WEST SUSSEX COUNTY COUNCIL CONSULTATION

TO:	Arun District Council FAO: Maria Tomalova
FROM:	WSCC - Highways Authority
DATE:	9 March 2022
LOCATION:	Land rear of Cedar End Eastergate Lane Eastergate PO20 3SJ
SUBJECT:	BN/14/22/PL 1 No. 5 bed detached bungalow with new vehicular access. This application is within CIL Zone 3 and is CIL liable as new dwelling.
DATE OF SITE VISIT:	n/a
RECOMMENDATION:	Advice
S106 CONTRIBUTION TOTAL:	n/a

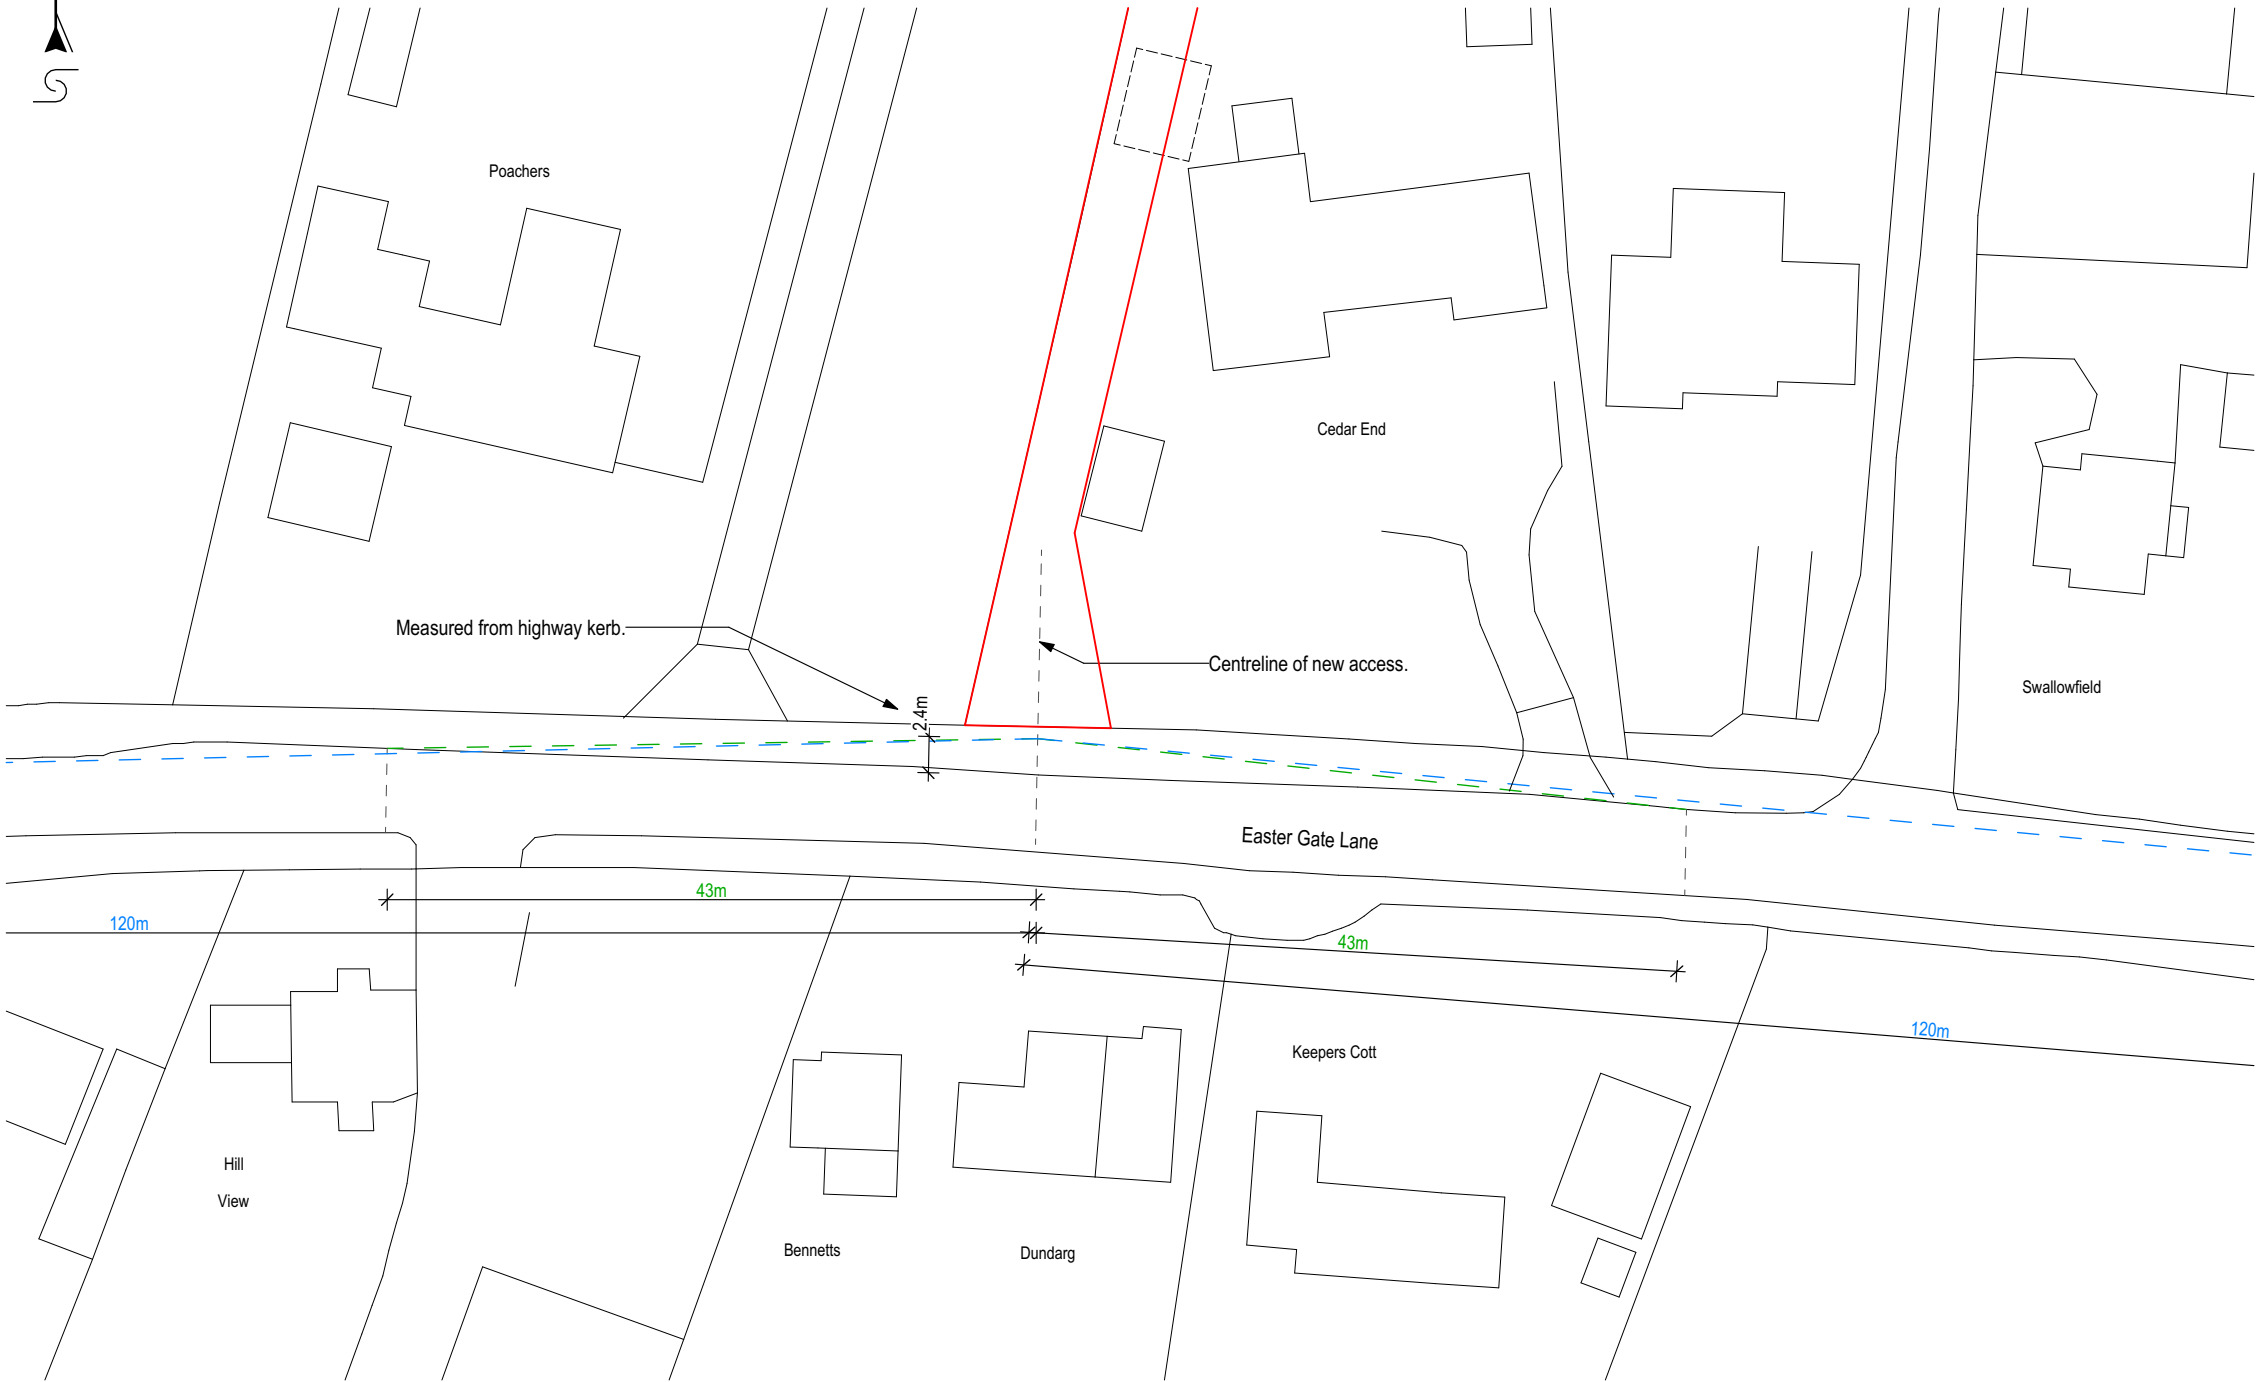
The proposed visibility splay plan demonstrates splays of 2.4 x 43m and 2.4 x 120m. As Eastergate Lane is subject to a speed limit of 40mph, splays of 2.4 x 120m are required. Whilst the splay plan does not show the full extent of the 120m splays, an inspection of WSCC mapping indicates that these splays are achievable in this location and are wholly maintainable within the public highway.
